Department Ref: SSD-6619-Mod-1
APA Ref: 445045

**RE: 509 Byrnes Road and 212 East Bomen Road, Bomen
Lot 21 on DP1128492, Lot 1 on DP850711, and Lot 3 on DP594679
S4.55 (2) Modification Application: Energi Battery Recycling Facility**

APA's response has been provided following review of the Enirgi Power Storage Recycling Consolidation Project Modification Environmental Assessment prepared by GHD, dated November 2019.

Figure 9 | Water treatment and irrigation locations

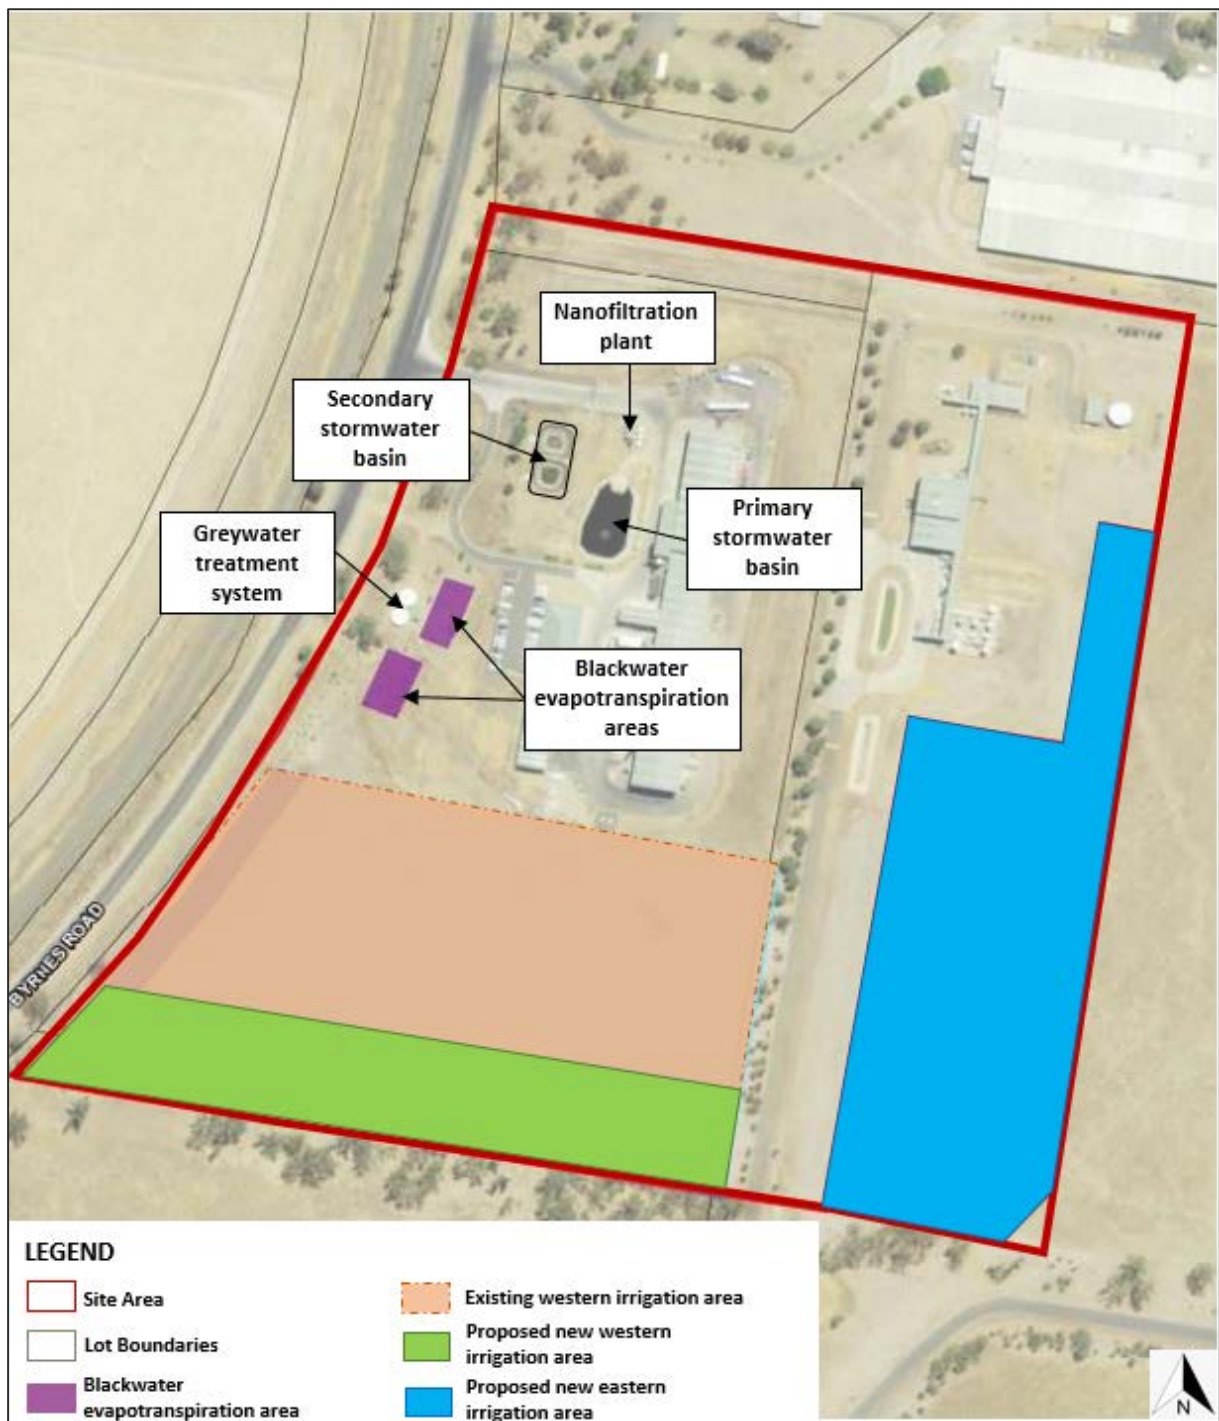
Figure 3-1 of the report shows the proposed Eastern Irrigation Area over APA's gas pipeline. While the plans reference APA's gas pipeline, it is not clearly marked as being for a high-pressure gas transmission pipeline. The level of risk associated with any intrusion into the easement is not adequately communicated to those undertaking site works. The easement should be clearly identified as an easement for a high pressure gas transmission pipeline on all relevant plans. In addition, the easement

should be hatched and notated as 'no works to occur without the prior authorisation of the pipeline operator'.

It is concerning to APA that a portion of the Eastern Irrigation Area is proposed to be located over APA's high-pressure gas pipeline easement. This proposed outcome is not acceptable, as the disposal of wastewater has the potential to create soaked soil over the easement area. In addition, the presence of sulphuric acid, a corrosive agent, in the soil due to the possibility of contaminated irrigation water may cause significant integrity issues for APA's two HPGTPs. In the very unlikely event that the presence of corrosive soil causes a corrosion rupture of either pipeline the safety of those at the Battery Recycling Facility would also be at risk.

APA's pipeline easement is not a suitable location for acidic wastewater disposal. Any acidic wastewater disposal must be outside the easement area, and designed to ensure no runoff will encroach onto the easement area.

The Modification plan should be amended to remove the Eastern Irrigation Area from APA's pipeline easement.
